**Notification of Modification Request – Norwest Private Hospital Expansion
(SSD 6074 MOD 2)**

Thank you for your email dated 25 December 2018 inviting Transport for NSW (TfNSW) comment on the Applicant's proposal to modify the development consent for the Norwest Private Hospital Expansion.

- provision of one additional storey (Level 4) with a floor area of 2066m² (resulting in a total floor space of 30,258m²);
- provision of roof level plant; and
- changes to access and parking, including 10 additional parking spaces.

Block/ Zone
A, B AND D
Drawing Title
**NEW WING PROJECT
BASEMENT LEVEL FLOOR PLAN (OVERALL)
MEDICAL SUITE EXPANSION**

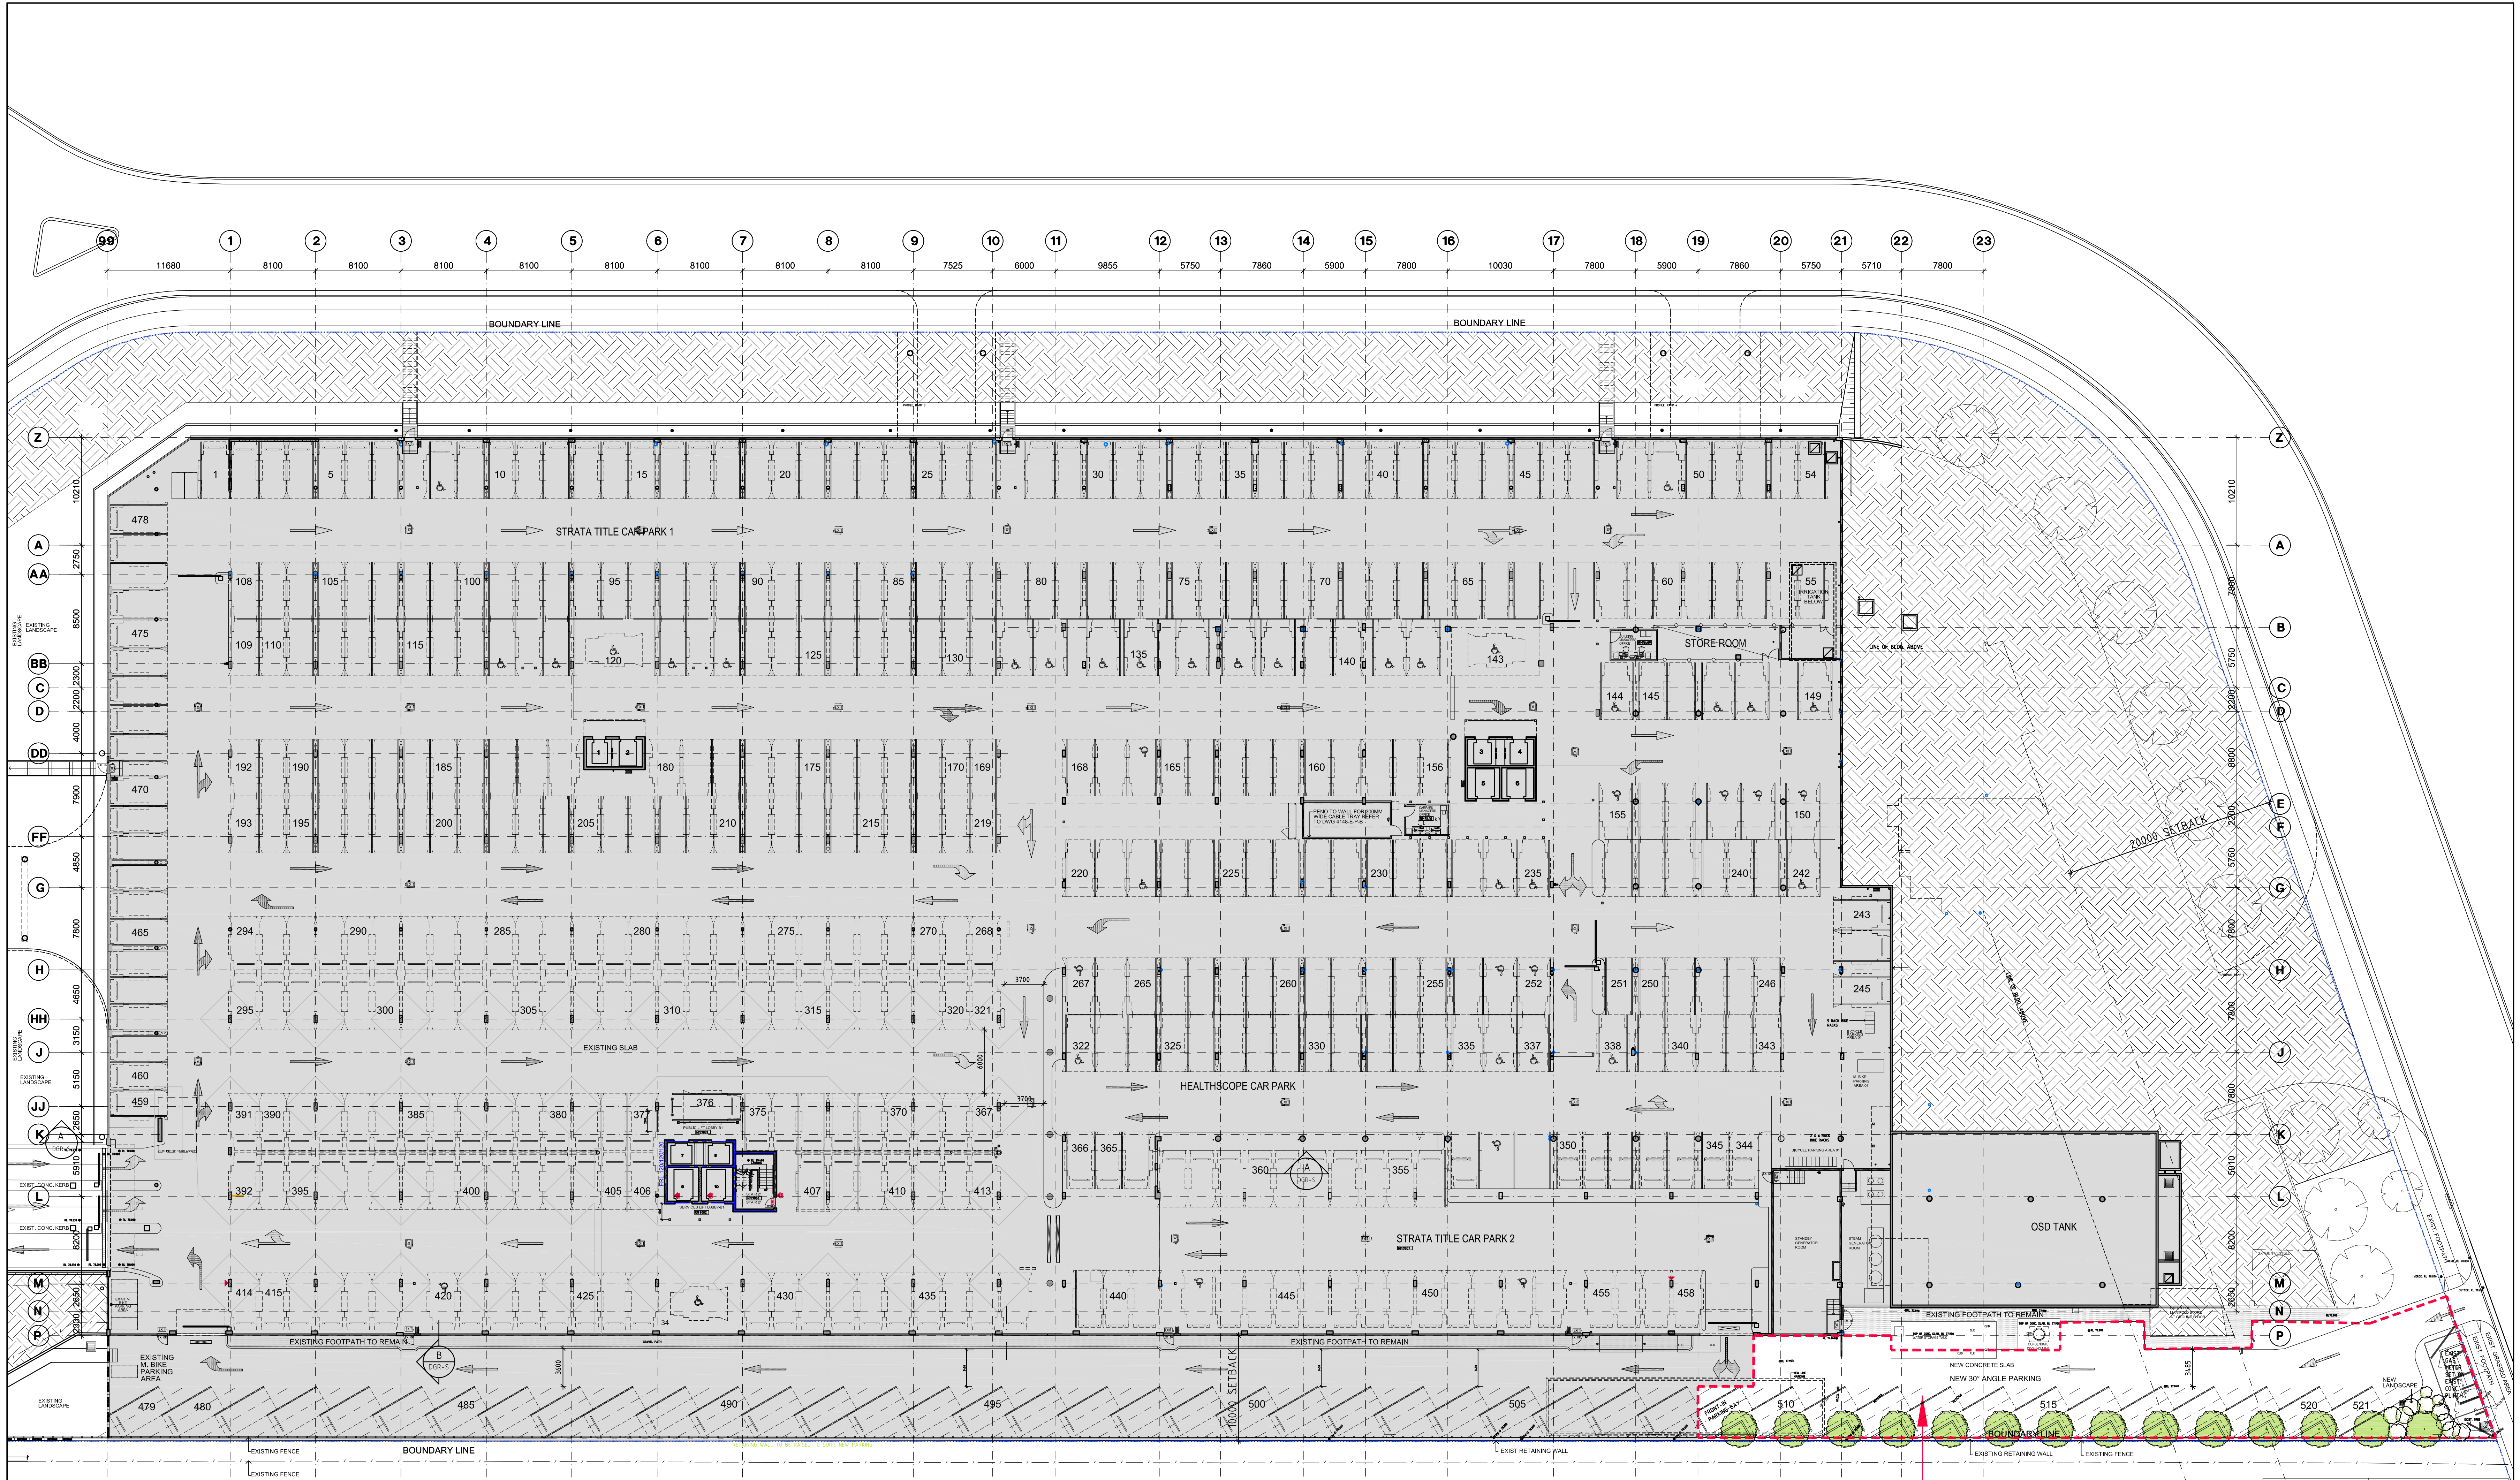
Based on the review of the proposed modifications and supporting documentation, the additional (and existing) staff and visitors associated with the expanded capacity of the hospital should be provided with bicycle parking spaces. Staff should also be provided with end-of-trip facilities. This will encourage the use of active travel and achieve the objectives of the Workplace Travel Plan.
